**Section 96A of the Town & Country Planning Act 1990 (as amended)
Town and Country Planning (Development Management Procedure) (England) Order 2015 (as amended) - Article 10**

Non-material amendment following the grant of EP/34/13 for minor amendments to west elevation to include high level window, removal of 1 No. window, amended sizes of 2 No. windows and larger door to balcony.

Sandgate House South Strand East Preston BN16 1PN

PROPOSED SECTION THROUGH
NEW HIGH LEVEL WINDOW 1:50

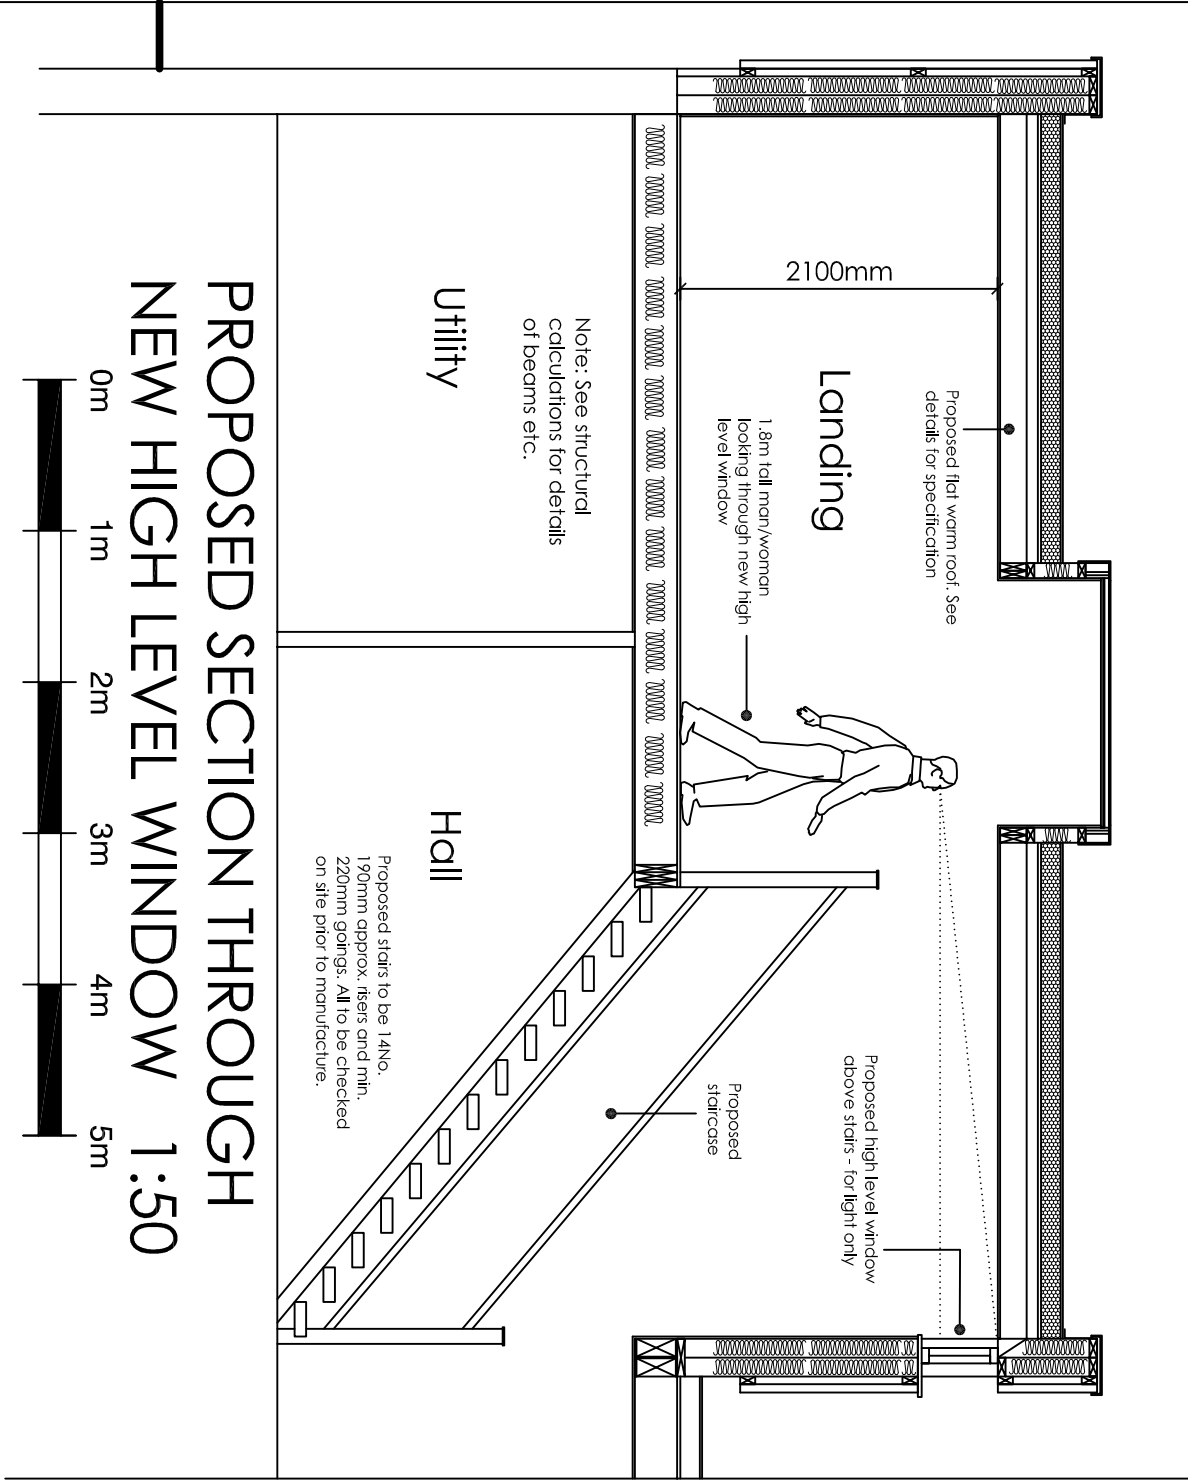
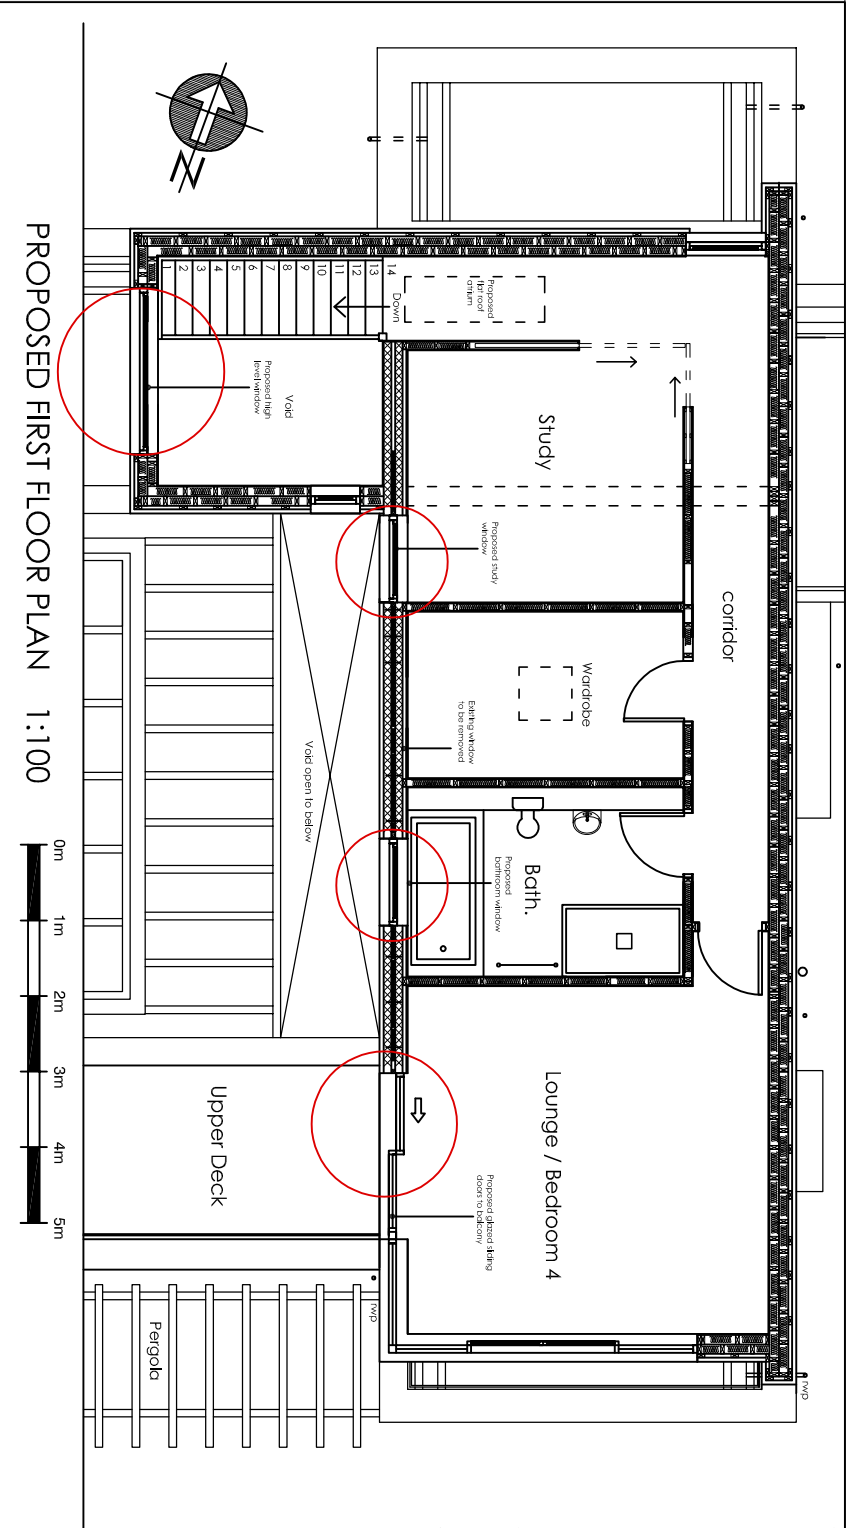
I refer to your recent application for a Non Material Minor Amendment. I note that you propose to include a high level window into the Western elevation, omit one window, amend sizes of two windows and increase the size of the door to the balcony.

Please note that plan 'Amendments to approved application EP/34/13 - AR-119-11 - May 2019' replaces 'Elevations As Proposed - sheet 1 - 1207 - SK25C - August 2012' in respect of the alterations to the 'West Elevation', note that other elevations are unaltered.
